Harnett County Government Complex
307 W. Cornelius Harnett Boulevard
Lillington, NC 27546

Re: Status of Improvement Permit Application #06-5-15432R

An attempt was made to evaluate your property for the purpose of issuing an Improvement Permit. The evaluation could not be completed for one or more of the following reasons.

SURVEY FOR:  
**TONY BAKER**  
 SURVEY OF: LOT 1 TED D. BROWN  
 MAP # 2006 PG 13  
 UPPER LITTLE RIVER TWP. HARNETT CO. NC  
 SCALE 1"=100' DATE 3/20/2009

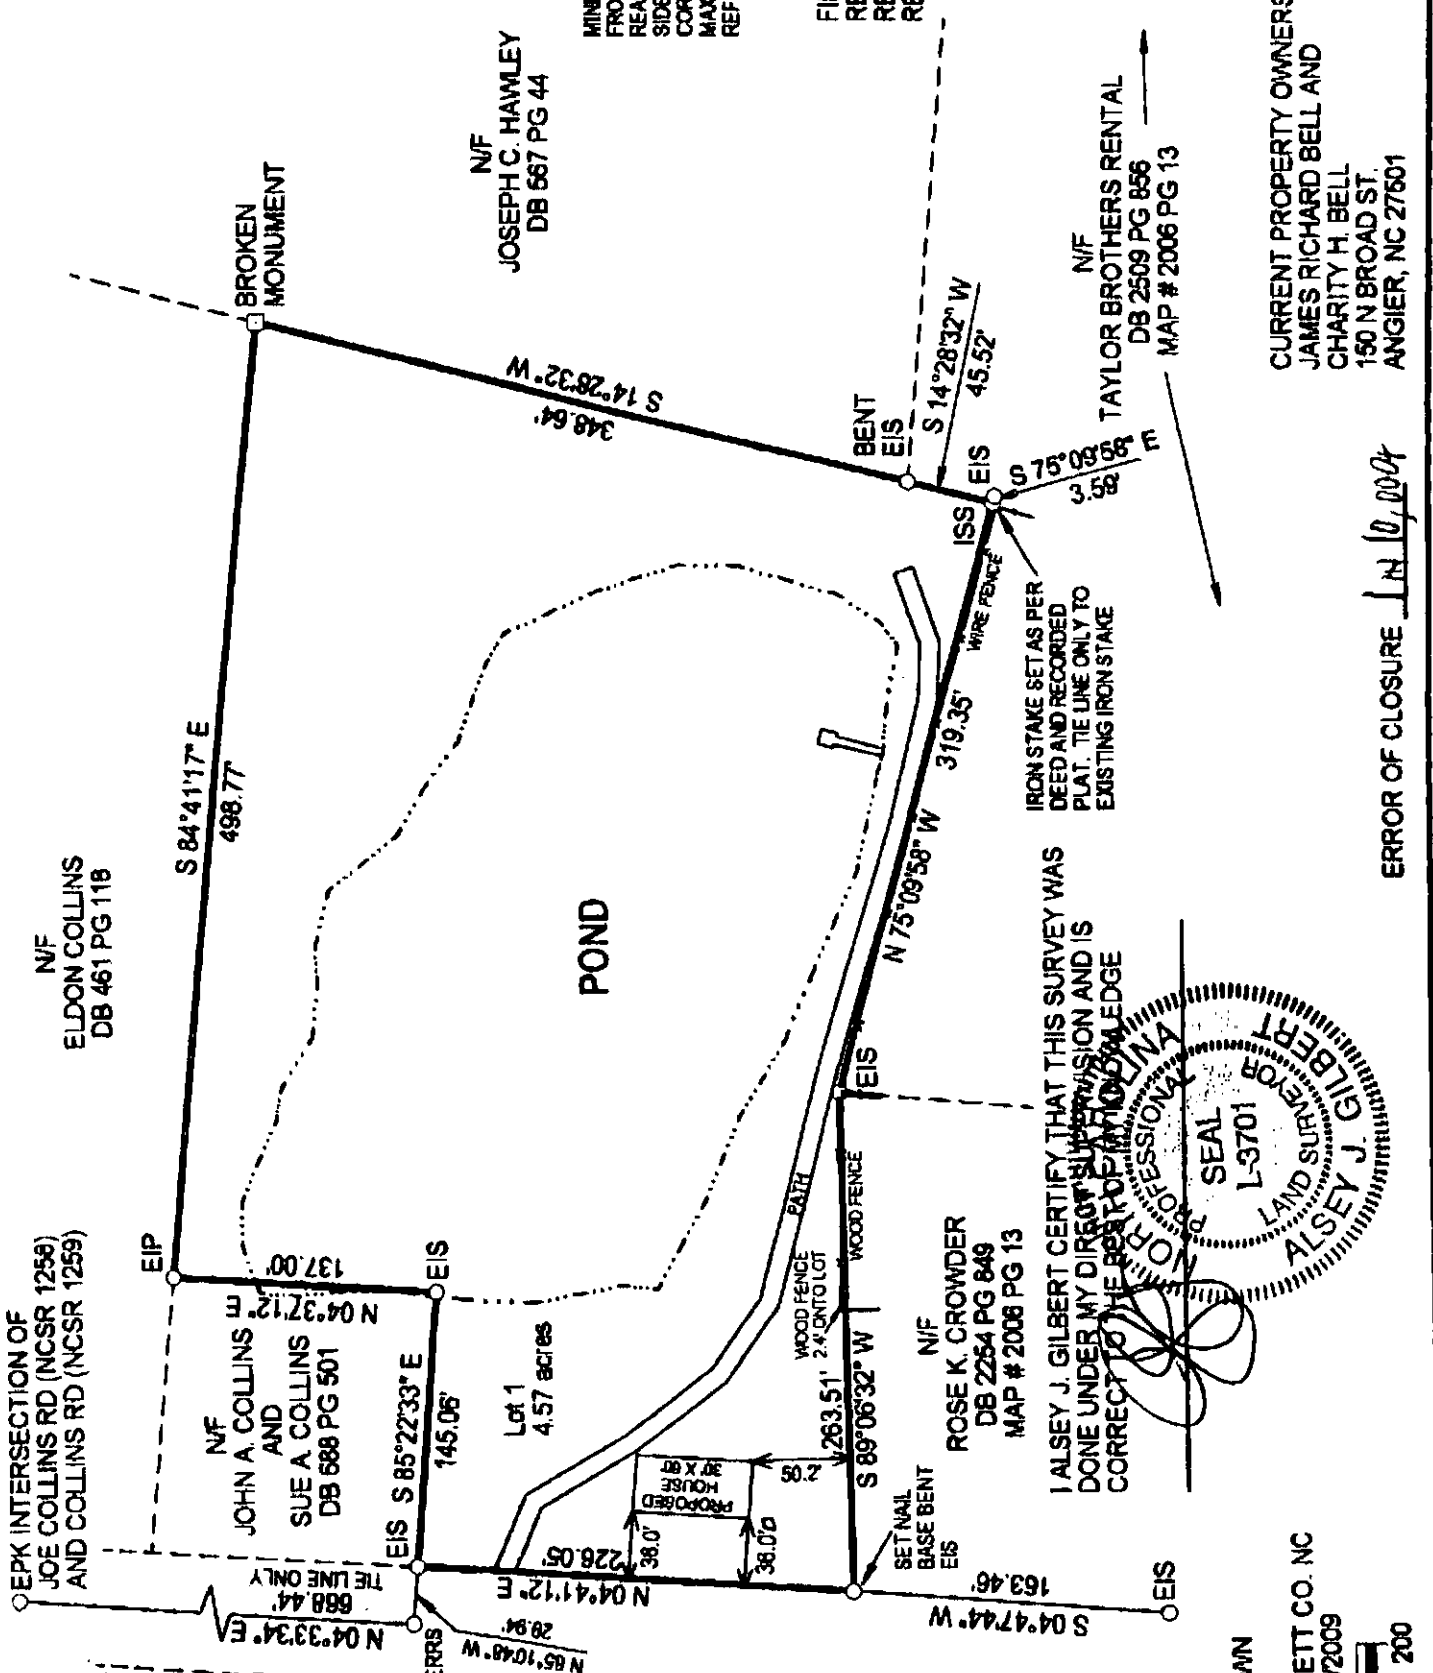
- 1. Property lines/corners not marked or labeled *(\$25.00 fee incurred)*
- 2. House corners not marked or labeled *(\$25.00 fee incurred)*
- 3. Directions not clear to property *(\$25.00 fee incurred)*
- 4. Property needs brush or vegetation removed
- 5. Backhoe pits required
- 6. Other – Move house as shown. This lot had been looked at before, and this is the required placement for the home. Submit new plot plan to Central Permitting.**
